File No: NTH18/00060/02

Your Ref: SSD-9264

**RE: State Significant Development SSD-9264 – Tamworth Solar Farm – Exhibition of EIS
Lot 186 DP 755340, 2209 Soldiers Settlement Road, Somerton**

Figure 2-1 – Designated Heavy Vehicle route to project site

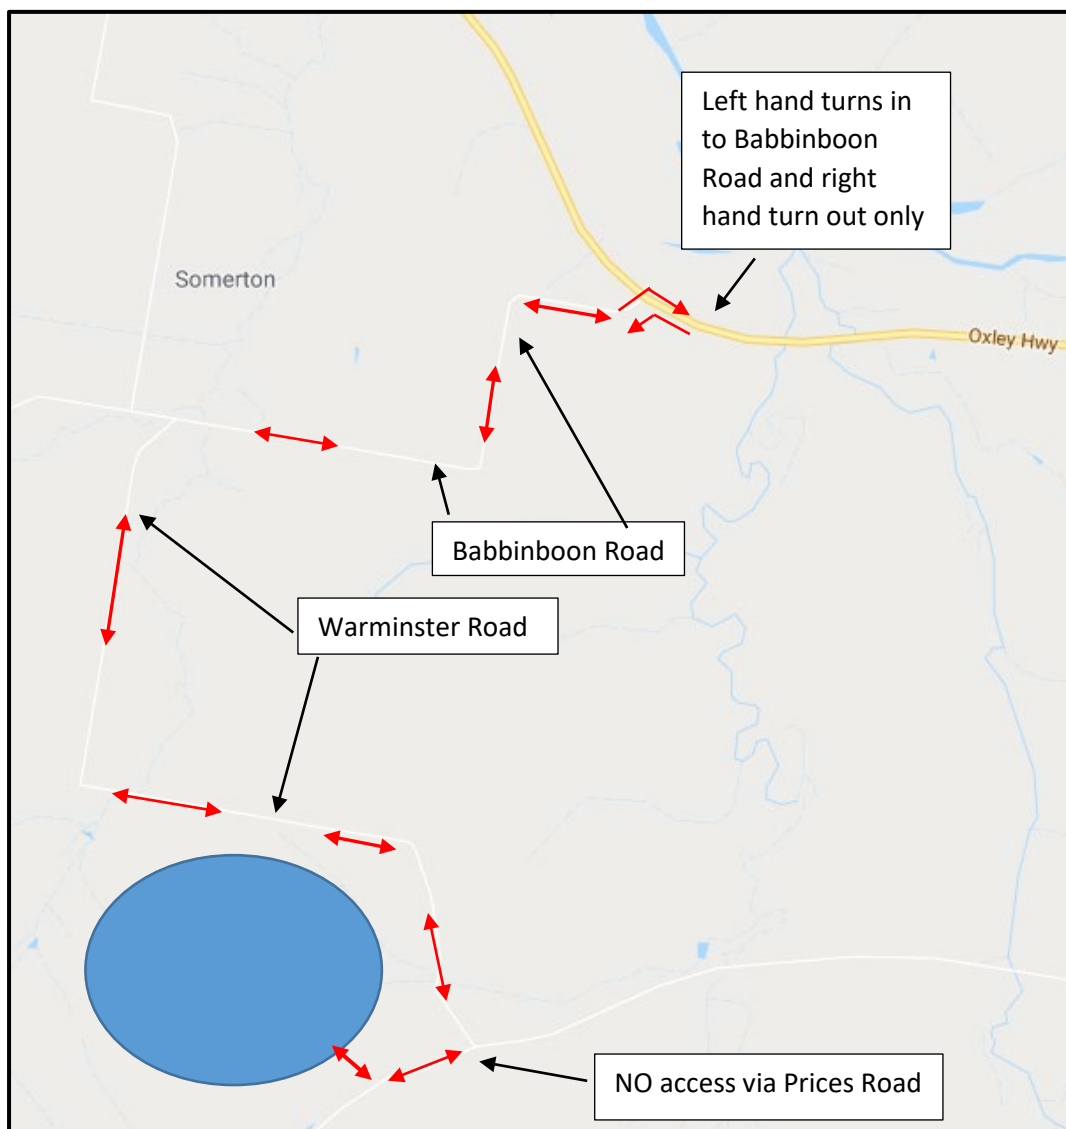
- Identify trip distribution including total two-way traffic volumes along the identified transport route/s, directional movements at key intersections and the proportion of heavy vehicles using the route. The mapping demonstrated in Figures 2-1 and 4-1 of the TIA identifies only identify the distribution of development related trips.

Figure 2-2 – Extract from Austrroads Part 4a showing requirements for left turn deceleration lane to be provided (AUL(S))

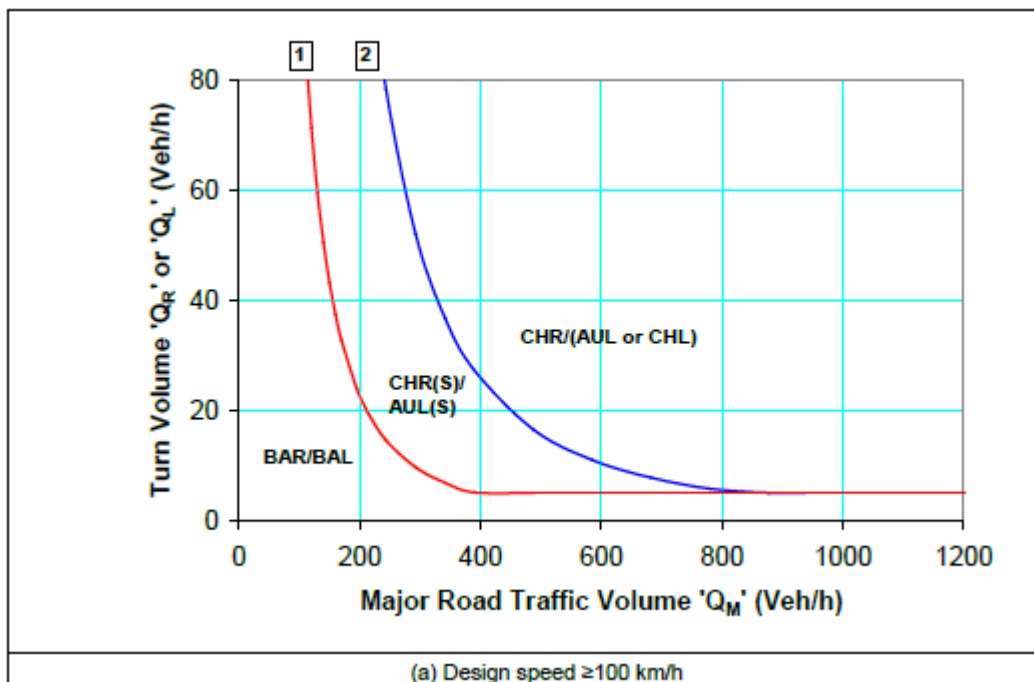
It is noted the TIA proposes an Austroads auxiliary left-turn (AUL) treatment to accommodate development traffic turning from the Oxley Highway into Babbins Road. Further consideration should be given to the likelihood of any vehicle turning right from the Oxley Highway at this intersection and it is recommended that measures are identified to address the risk arising to any vehicle turning from the travel lane of the highway.
